**EN010122. Comments relating to the Non Material Change application for:
The Oakland's Farm Solar Park Order 2025 (SI 2025/739) & correction 2025 (SI 2025/1070)**

I shall comment upon each of the proposals based on the numbering appearing in the document: Non-Material Change Supporting Statement (EIA Addendum). Document Ref: EN010122/NMC/6.1

Document Ref: EN010122/NMC/2.3

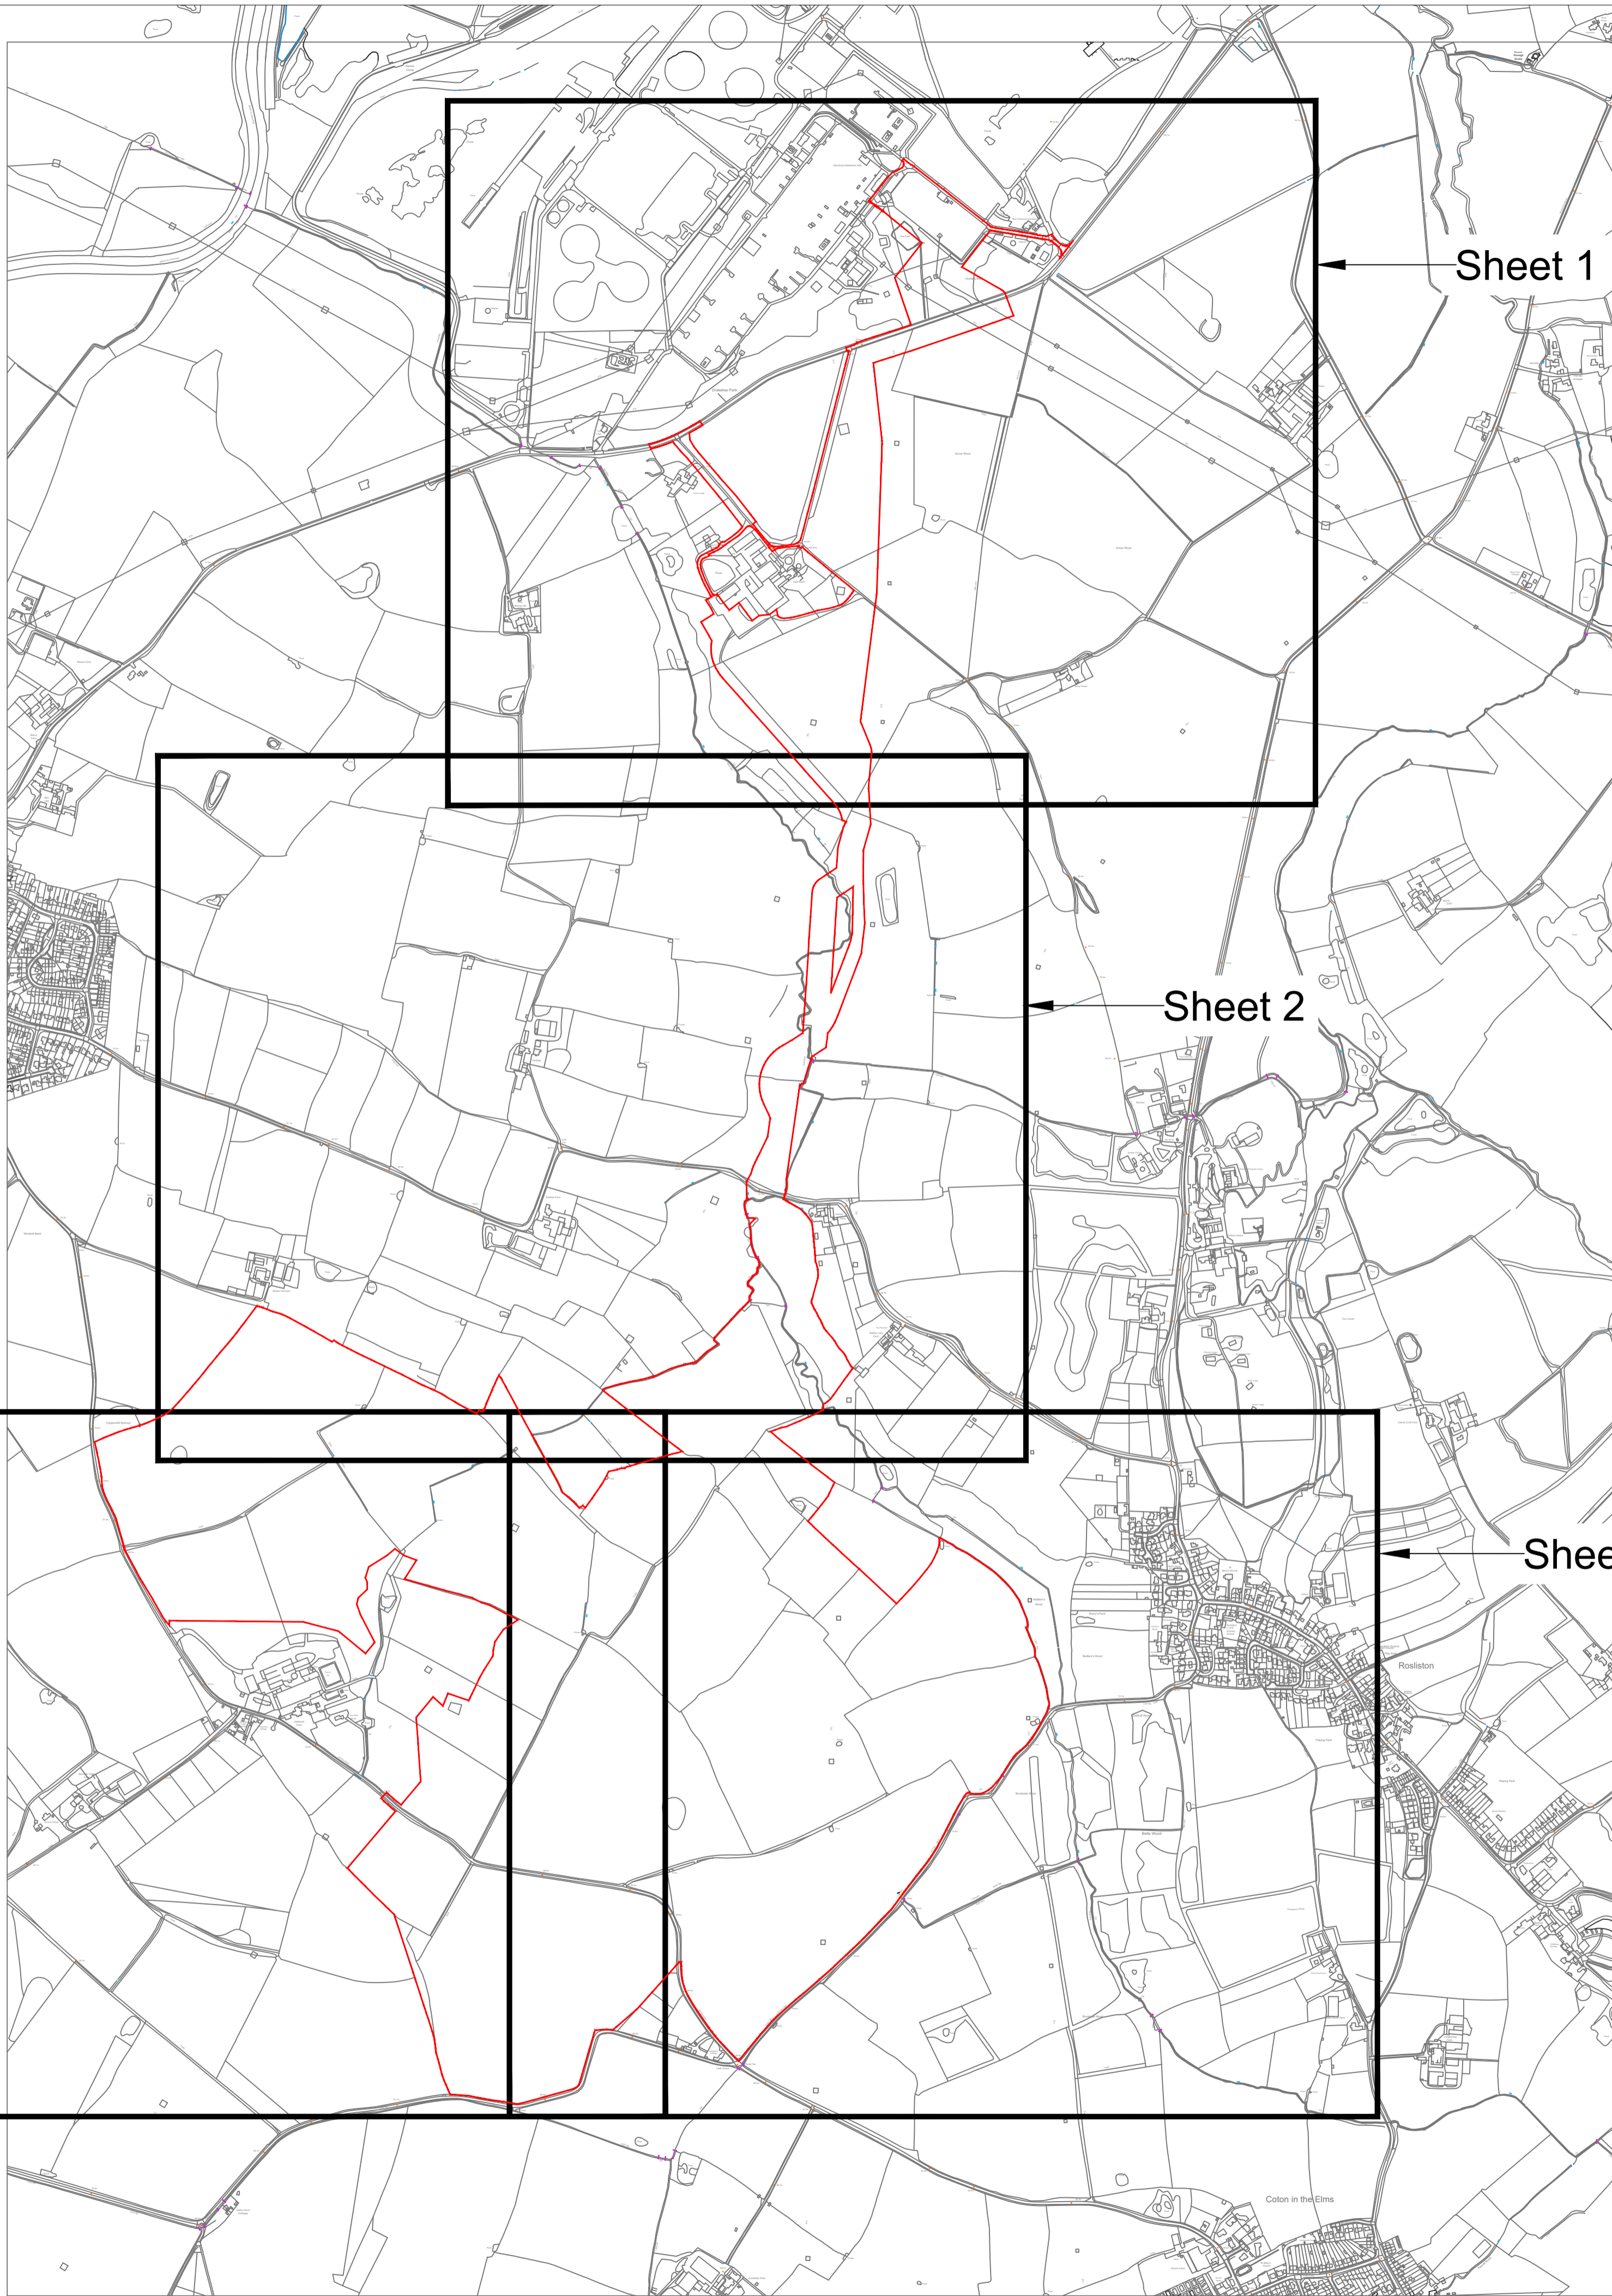
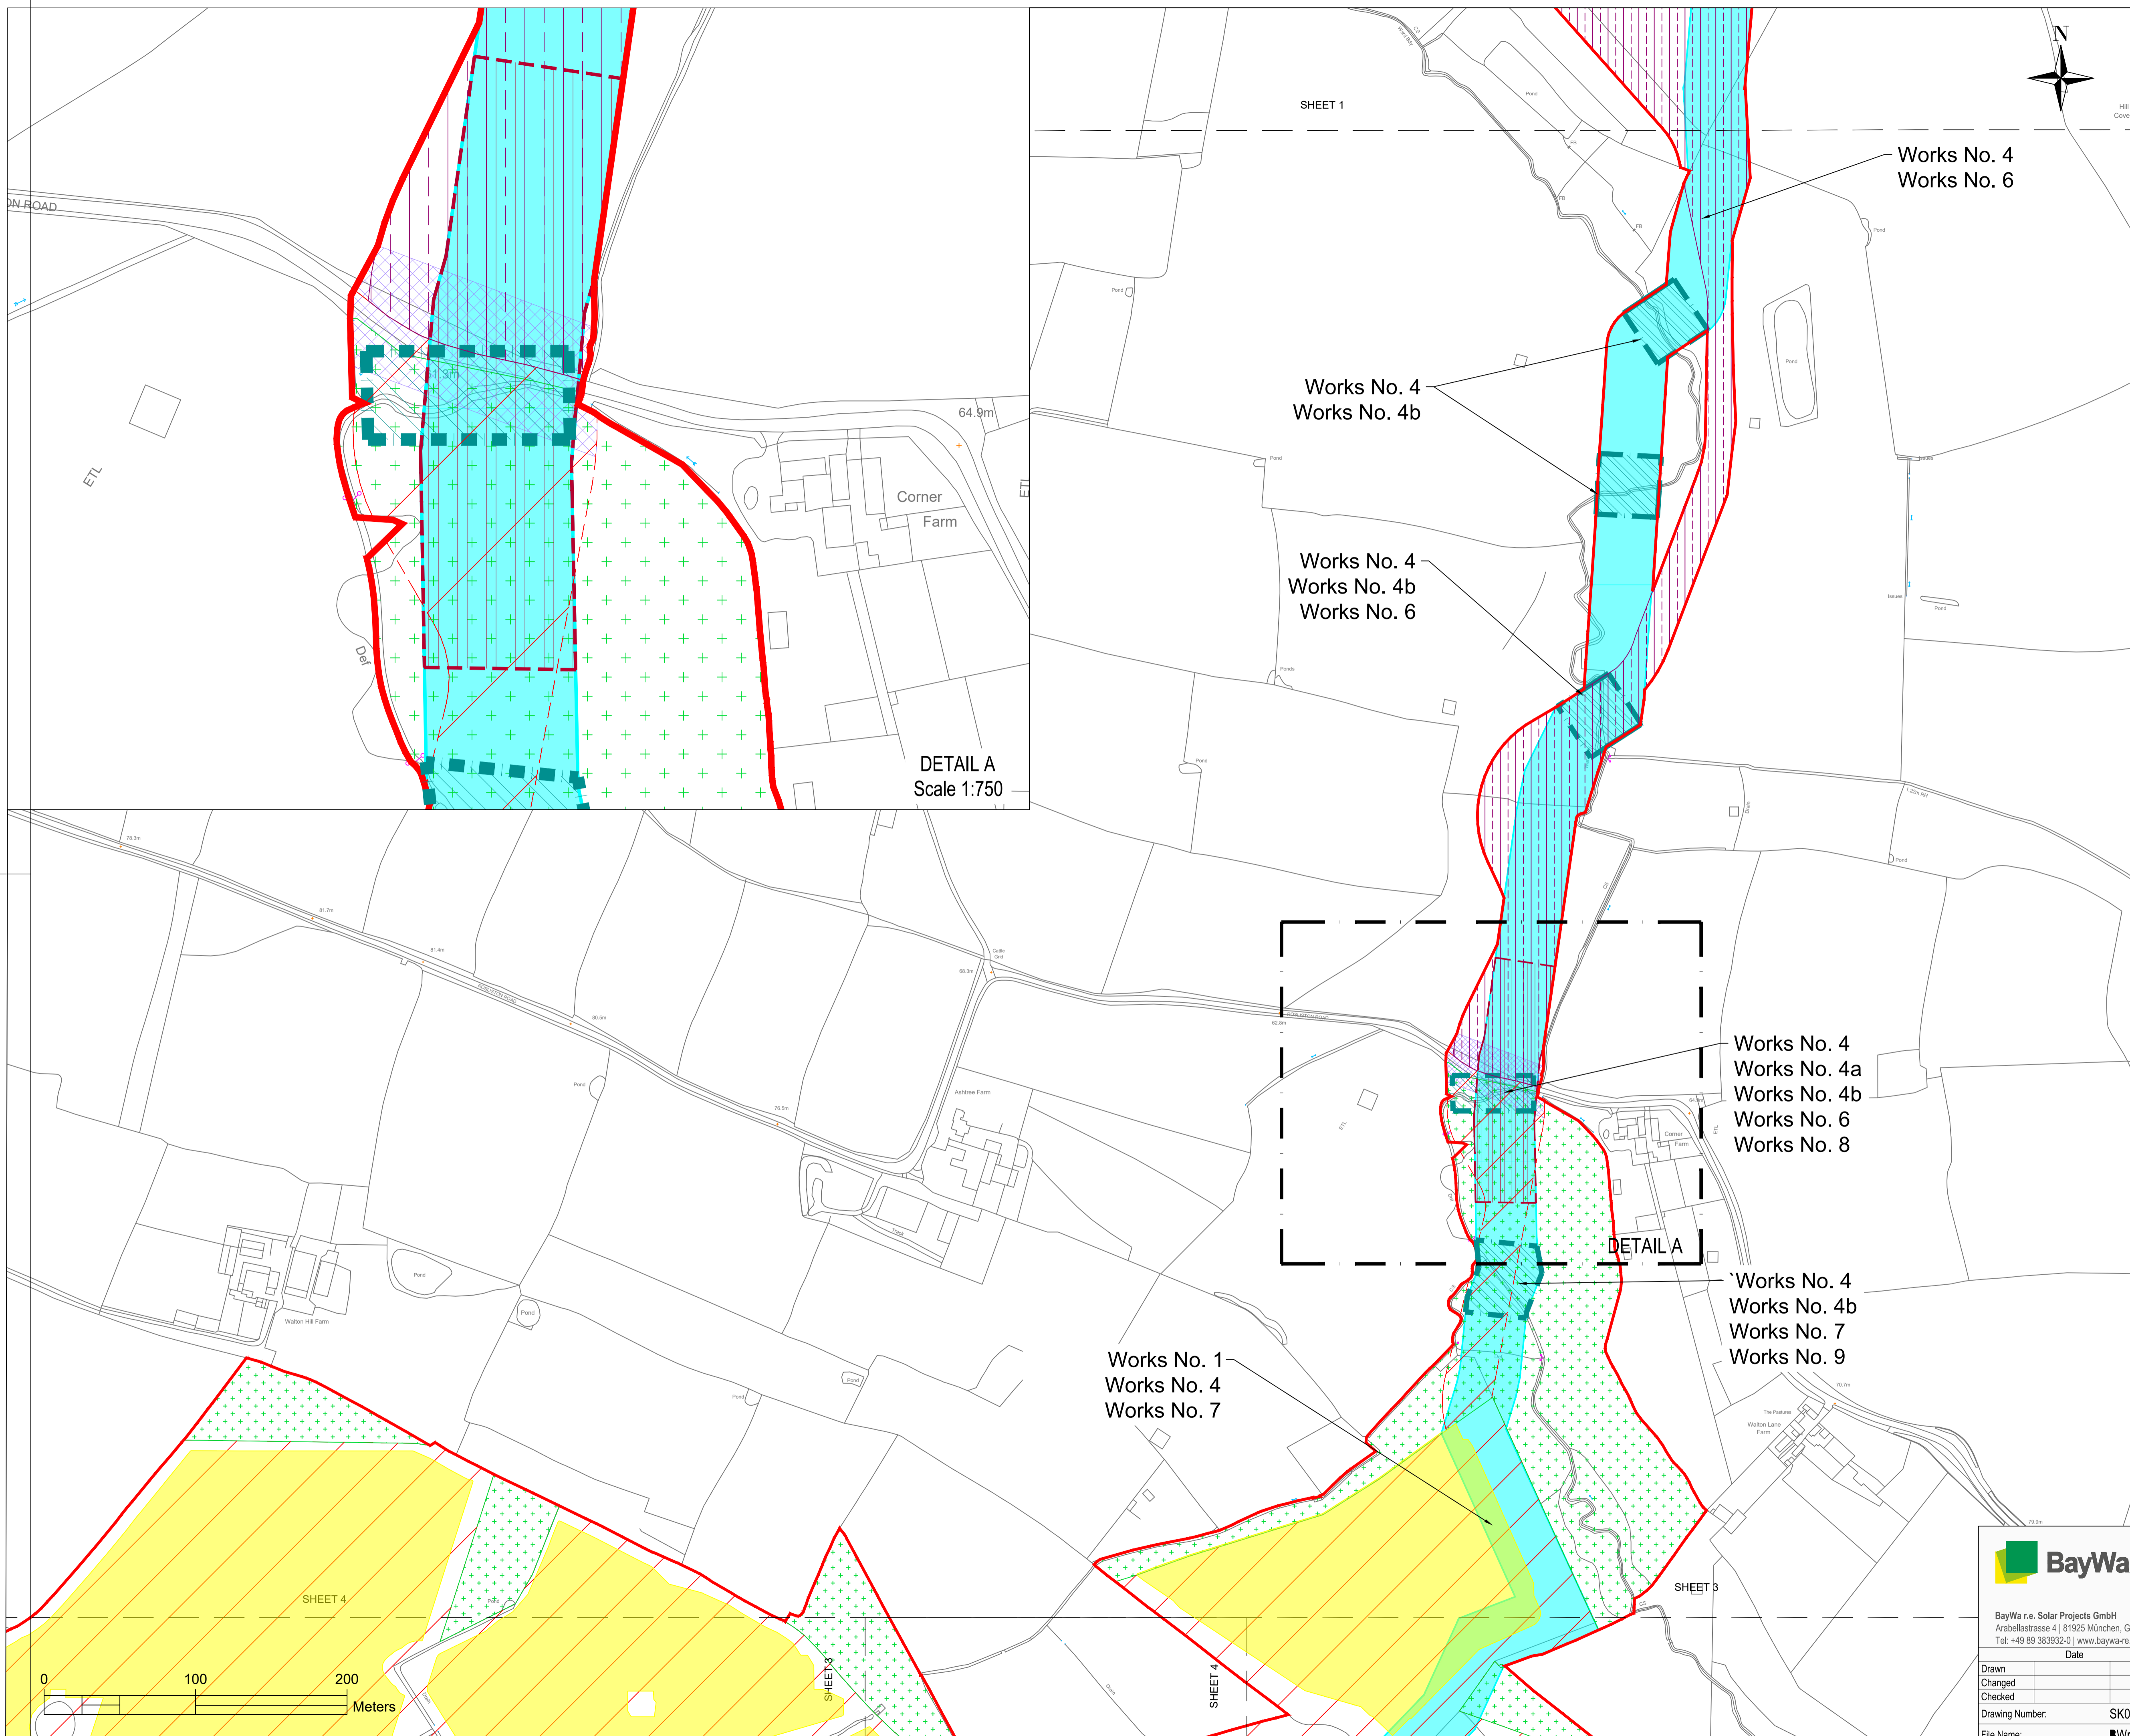
It seems from the diagrams of the extended solar panel areas that some hedgerows / trees / woodlands may be impacted with the panels encroaching closer than the 5m existing hedgerow boundary and/or the 15m tree root protection zone. Can this be checked and verified please?

If the solar panels now cover 3.4% more area than previously reviewed, how is this increase likely to impact on the drainage and subsequent flood management proposals?

One of the main areas where the solar panel coverage has increased borders Coton Road to the North West of Oakland's Farm. This road frequently floods in the dip by Copperhill Spinney and near the entrance to the farm / Chilled Hub (at the "slow" sign in the road). Can the applicant show that the increased run-off from the panels near the road do not exacerbate the flooding at the bottom of the hill?
